**RE: RIDBC CENTRE FOR EXCELLENCE (SSD 10451)
CULLODEN ROAD, MACQUARIE UNIVERSITY
RESPONSE TO SUBMISSIONS**

I write on behalf of RIDBC in relation to the current SSD DA for the new RIDBC Centre for Excellence at Culloden Road, Macquarie University and provide a response to submissions arising from the public exhibition of the project. I note agency submissions were received from the following:

In addition to a response to the submissions made and the Department's summary of key issues, WMK has also adjusted minor aspects of the development as a result of design refinement. These are submitted as part of this response for assessment and approval in the interest of avoiding a potential later need to seek modification of the consent.

Consulting Services Building Courtyard - Plan

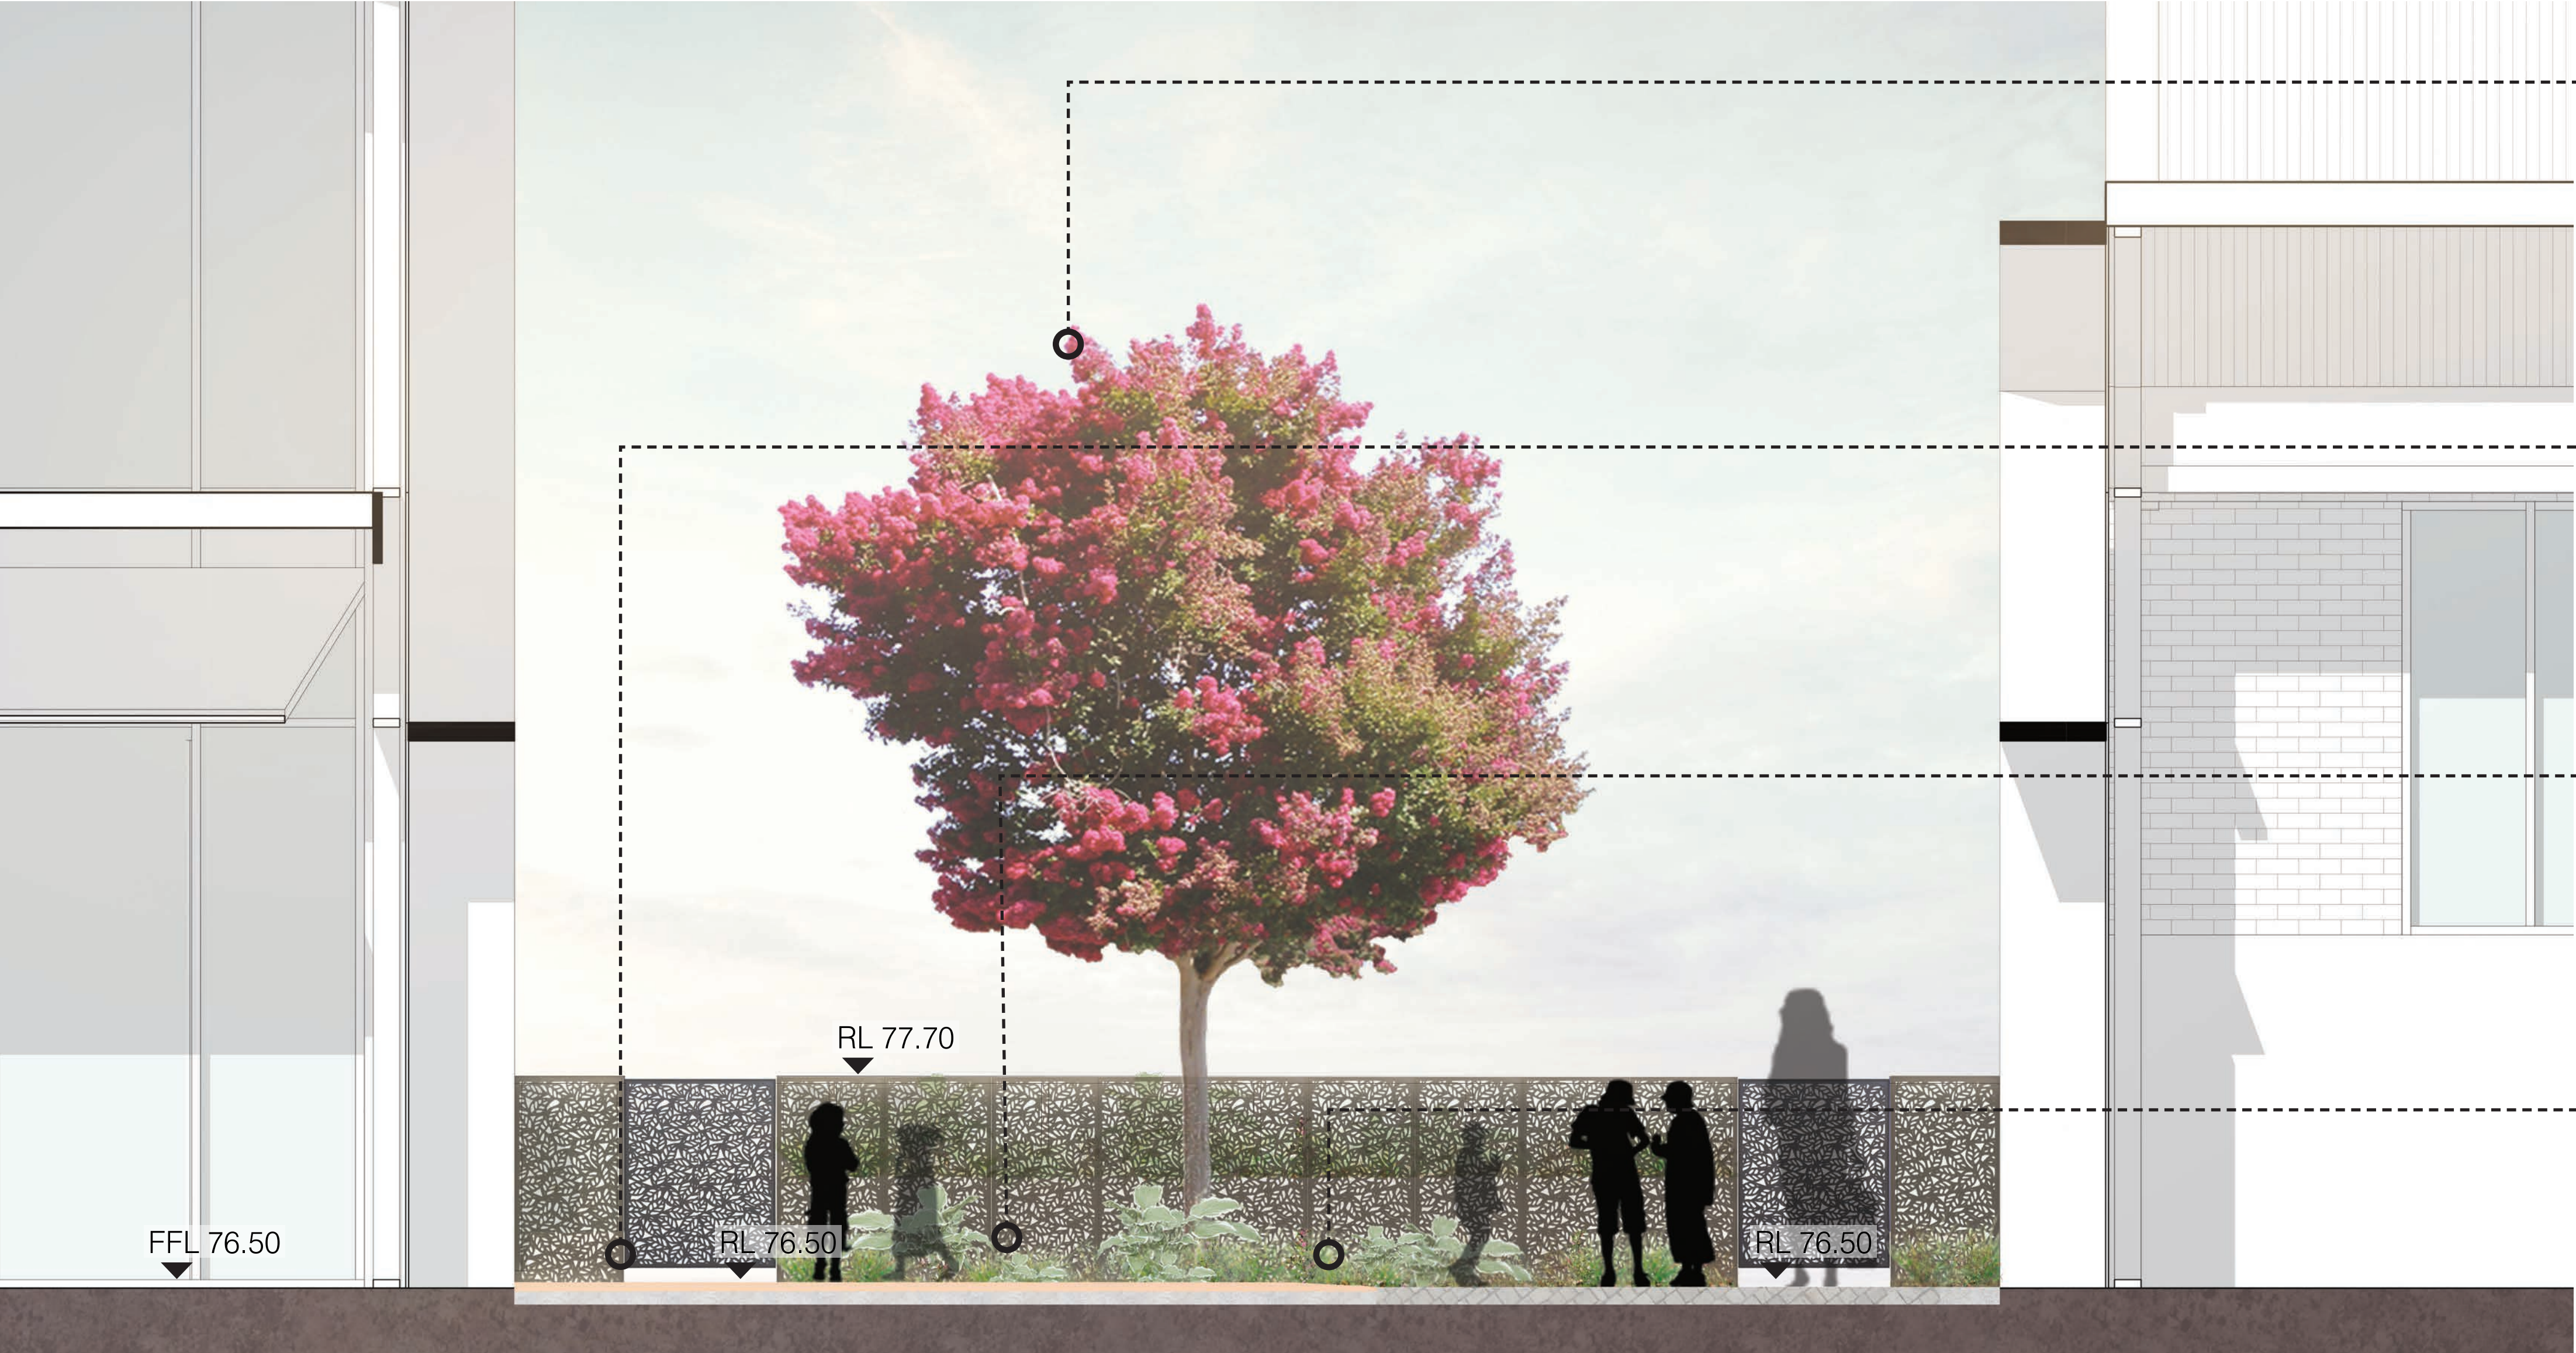
- The landscape shown in the architectural plans has been updated to better align with Oculus' current design – in particular for the primary school COLA area and the central courtyard of the main building. Note, the planter layout in the preschool courtyard has been adjusted to ensure the target outdoor learning area for students is met. Swales to the south of the site have also been shown.
